Ribble Valley Borough Council
Housing & Development Control

Application no: **3/2021/0539**

Address: **Ravenswing Farm Further Lane Mellor BB2 7QB**

Proposal: **Proposed conversion of existing garage space into living accommodation with mezzanine level; single-storey extension to rear; loft conversion to form 2 new bedrooms; conversion and alteration of outbuilding to form new detached double garage. Resubmission of 3/2020/0770.**

Ravenswing Farm, Mellor for Mr & Mrs Chudasama Proposed extension & alterations - GARAGE PLAN AND ELEVATIONS	1:50 @ A2	04 05 21
		2957
		SK.02

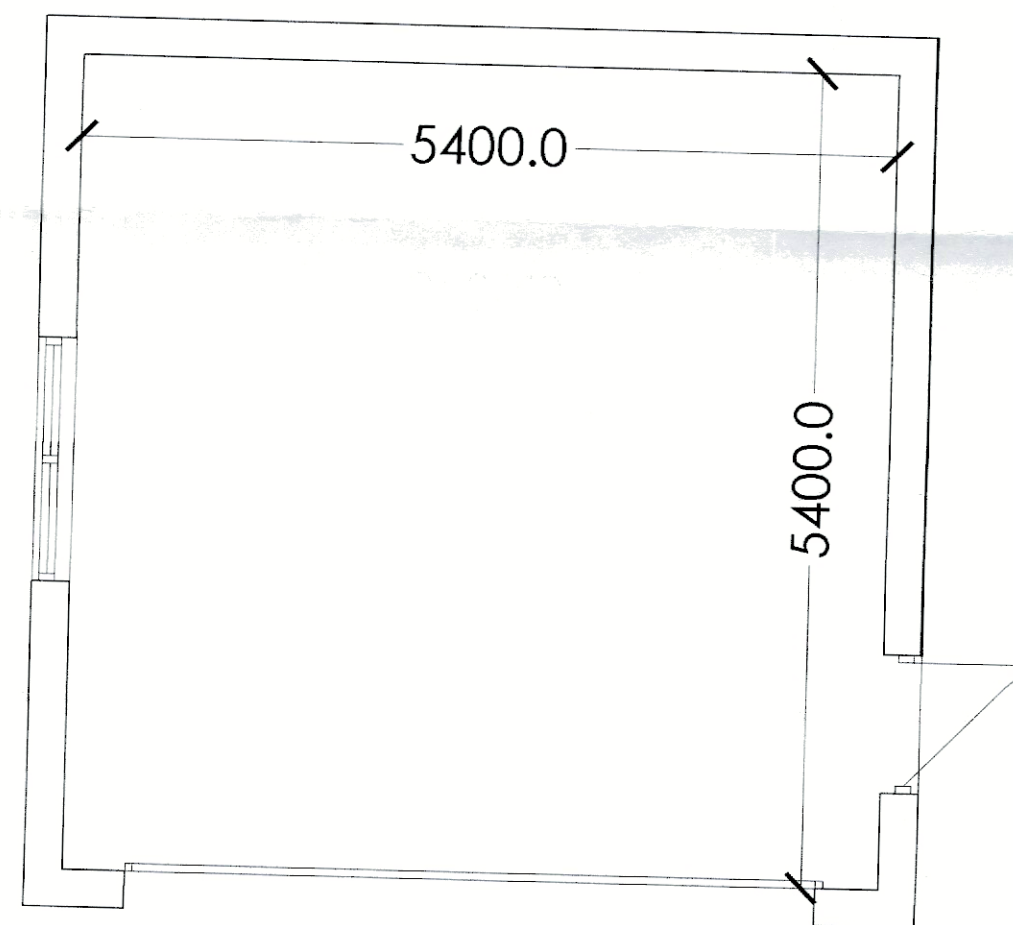
The LHA area aware that the Applicant is proposing to convert an existing outbuilding into a double garage which will provide 2 car parking spaces for the site. However, the dimensions of the garage which measures 5.4m x 5.4m and is shown on Bramley-Pate drawing number SK.0.2 titled "Proposed extension and alterations-Garage Plan and alterations" does not comply with the LHAs guidance when a garage is providing 2 car parking spaces. This is because a double garage is required to have the minimum dimensions of 6m x 6m.

Notwithstanding this, the LHA have reviewed the site and while the proposed garage is unable to provide 2 car parking spaces, the site has adequate space to provide 3. One in the proposed garage and 2 on the forecourt. Therefore, the LHA have no objection to the proposal.
